First floor rear extension, conversion of roofspace to habitable use. Part two storey part single storey front extension and demolition of existing conservatory and adjustments to flat roof dormer to north elevation on existing dormer to incorporate pitched roof.

Flint Barn Peak Lane Kingston

Thank you for your internet representation made on 17th March 2020 which has been recorded as '**an objection**' with the comments as follows:

Client	
Mr K P & Mrs V L Eaton	
Project	
PROPOSED EXTENSION TO FLINT BARN, PEAK LANE, KINGSTON GORSE, WEST SUSSEX, BN16 1RN	
Title	
PROPOSED SECTION	
Drawing Status	
PLANNING APPROVAL	
Drawn	Checked
KPE	
Scale	
1:50 @ A3	
Date	
31 Jan 2020	
Job No	
20/01	
Drawing Number	
2020/Jan/Plan. 004

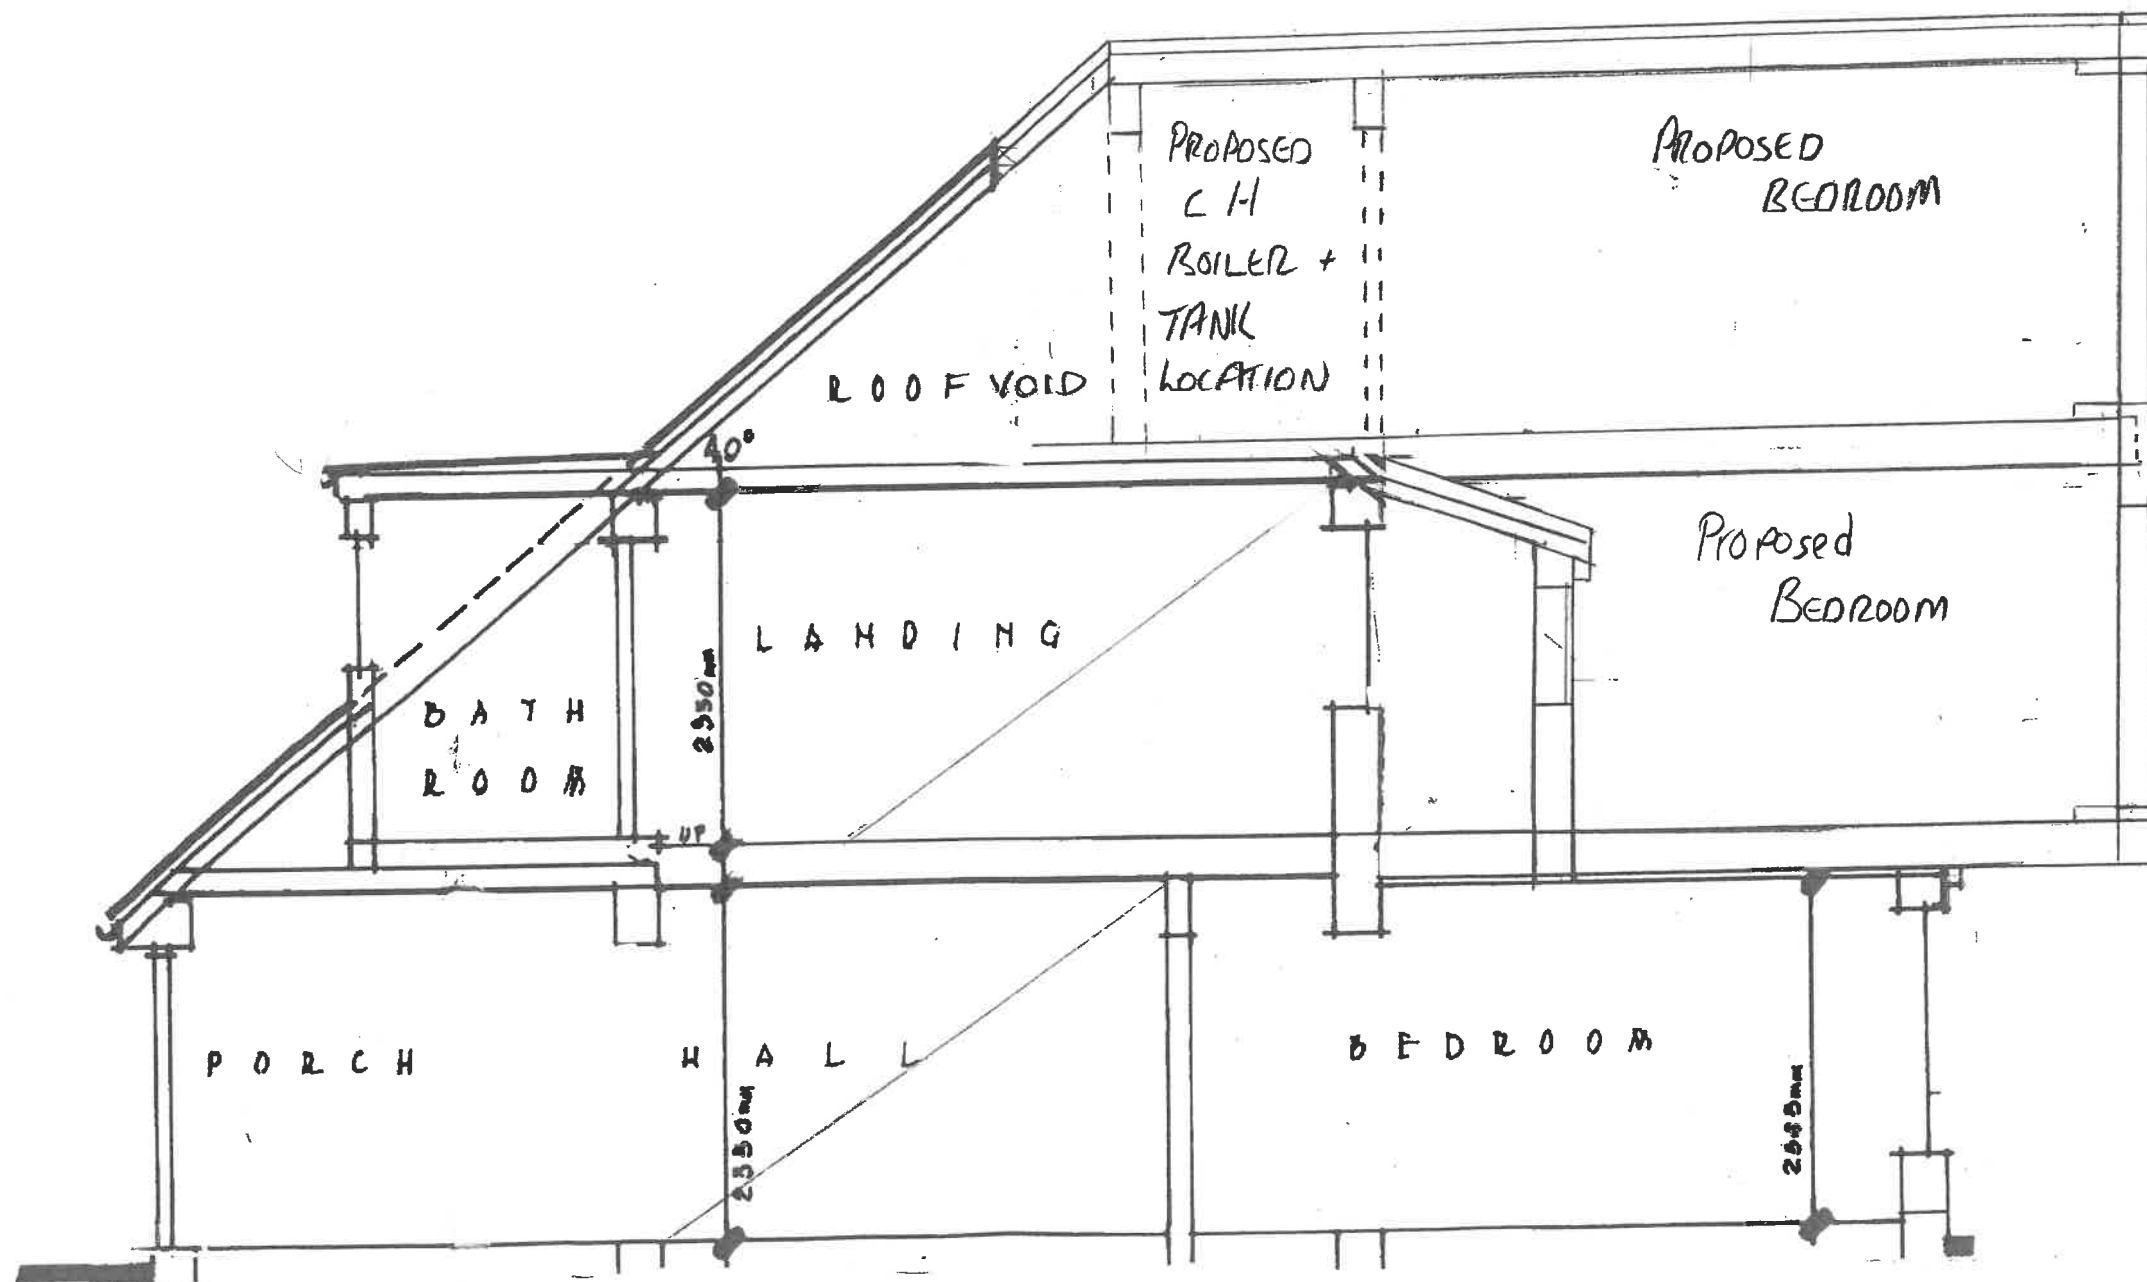
Firstly, the height of the proposed roof space conversion appears significantly higher than the current roof height, which is already substantial.
